**REQUEST**

Current Zoning: UC (uptown core)  
Proposed Zoning: UMUD-O (uptown mixed-use development, optional)

Approximately 2.73 acres bound by the south side of South College Street, west side of East Martin Luther King Jr. Boulevard, north side of South Brevard Street, and east side of East Brooklyn Village Avenue.

**SUMMARY OF PETITION**

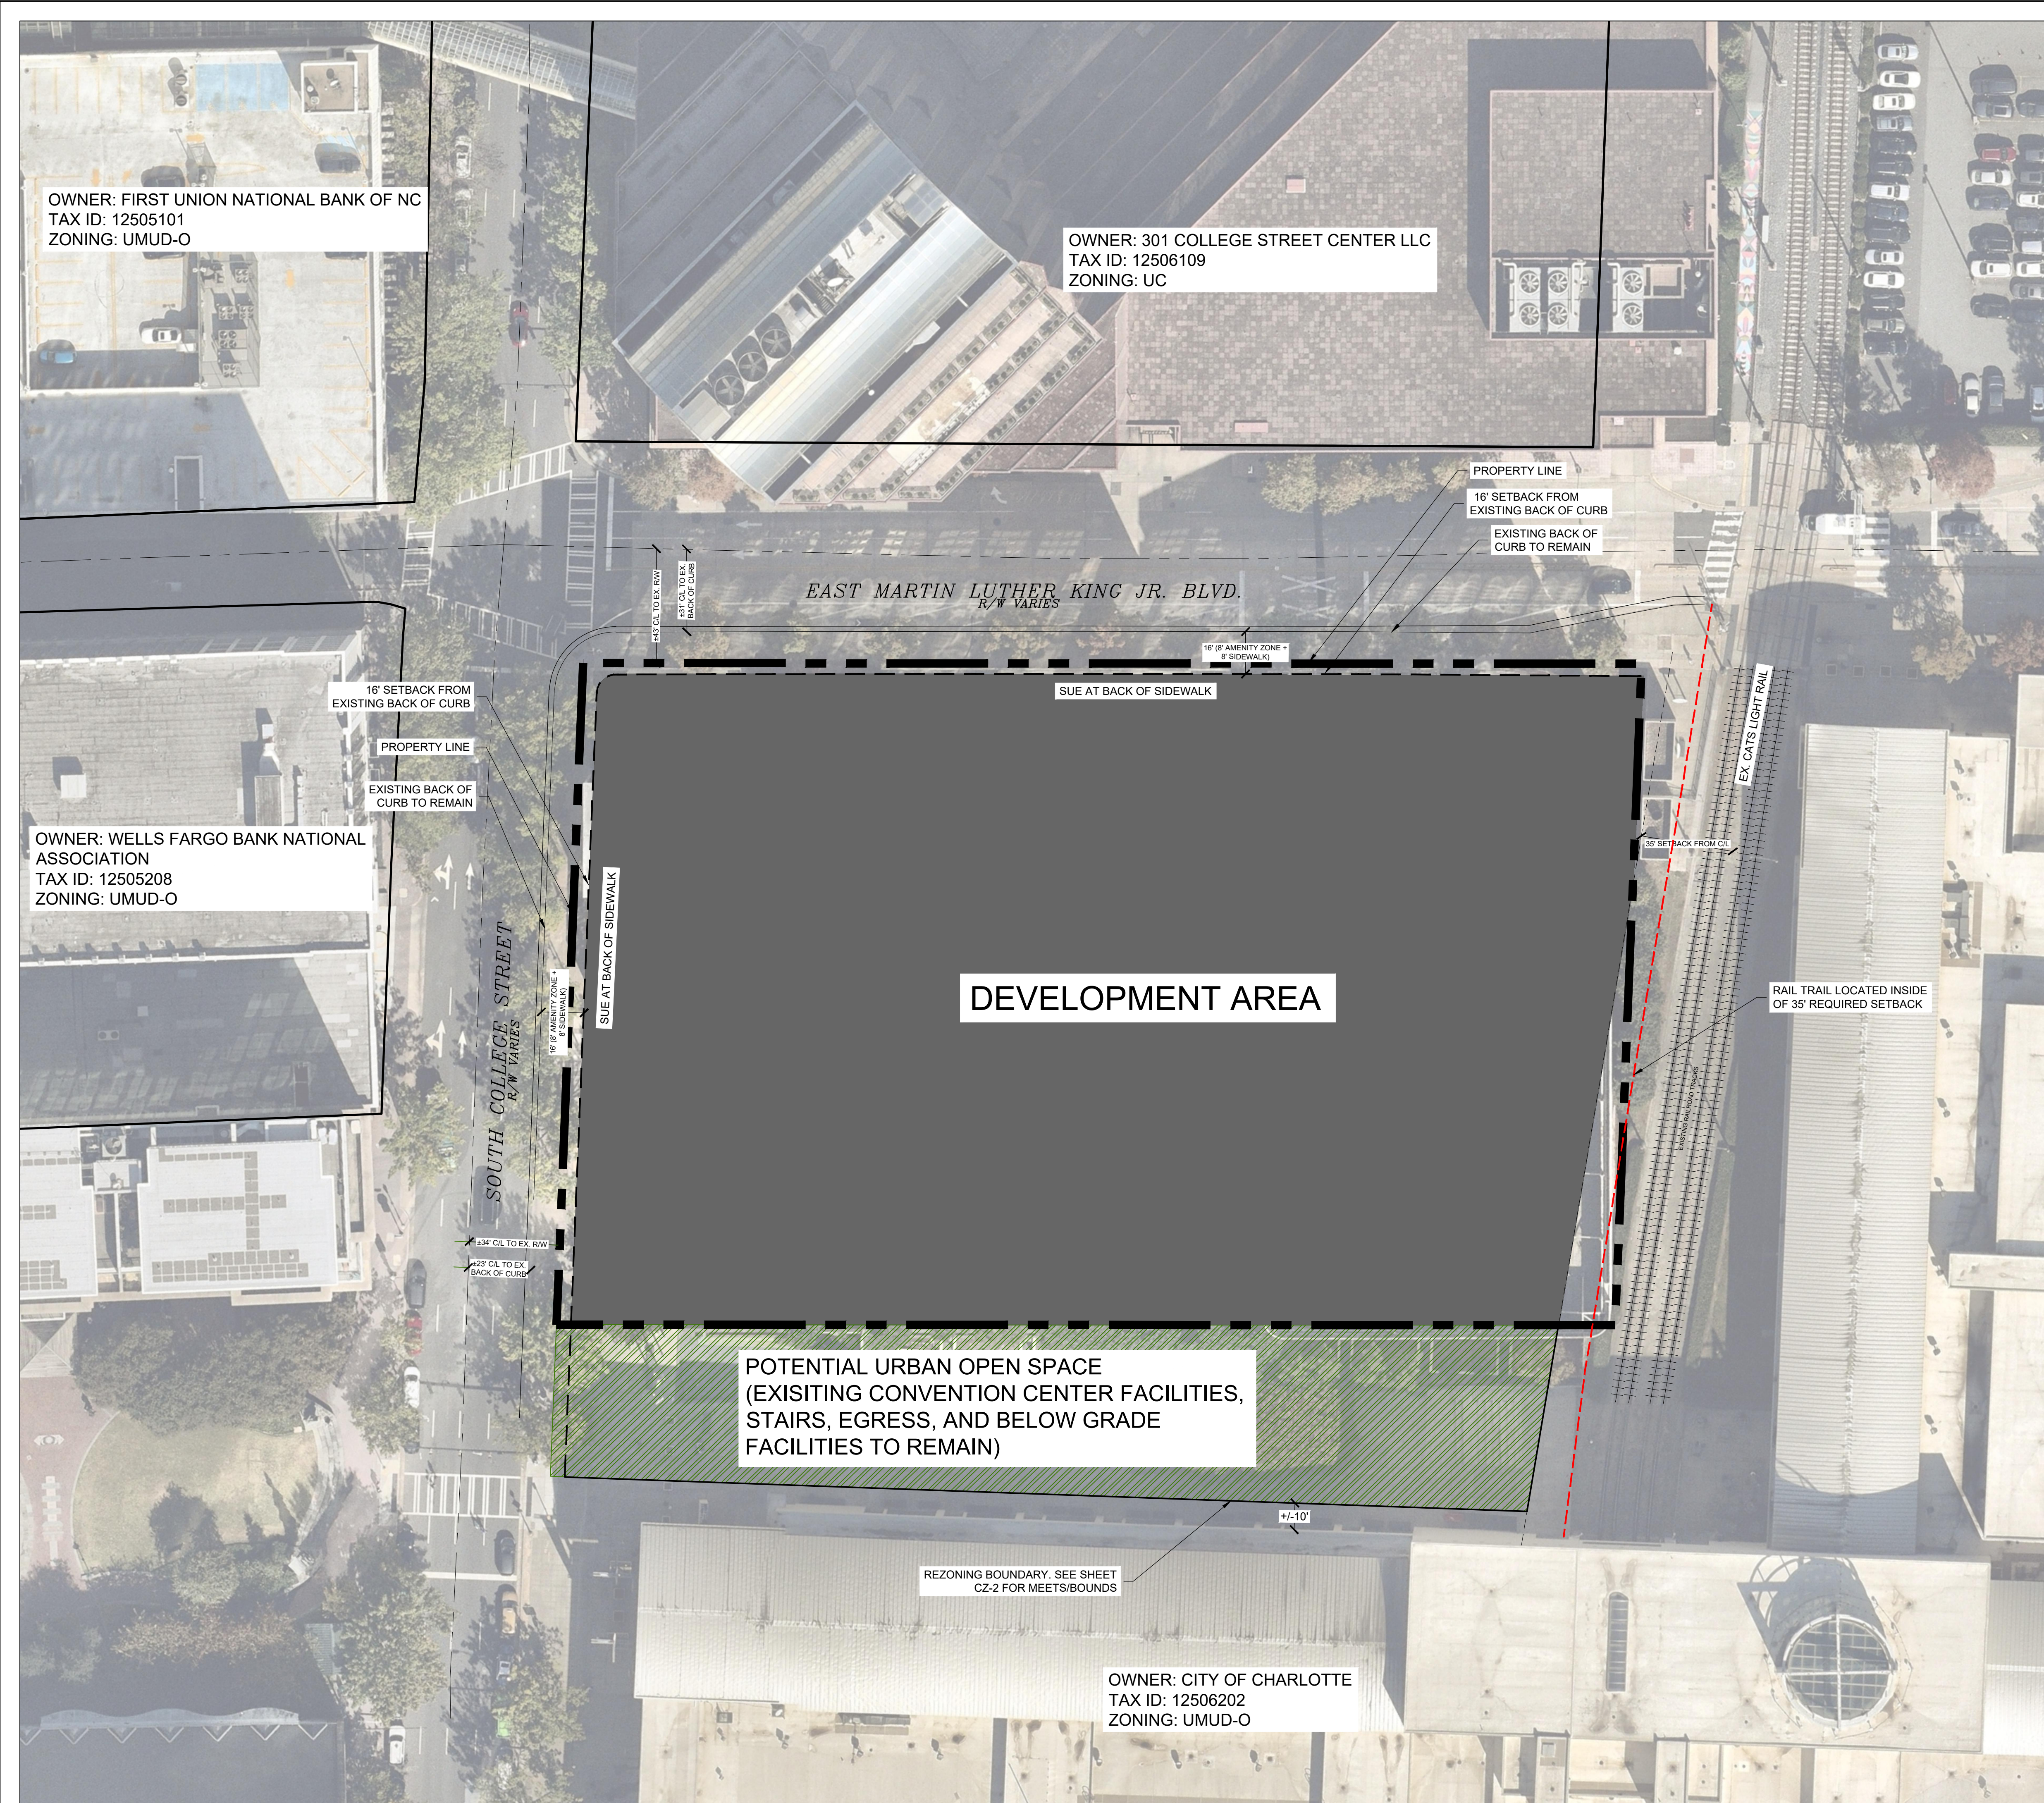
8. Remove site plan callout and other references stating that the existing convention center facilities along the Rail Trail corridor will be relocated by others.
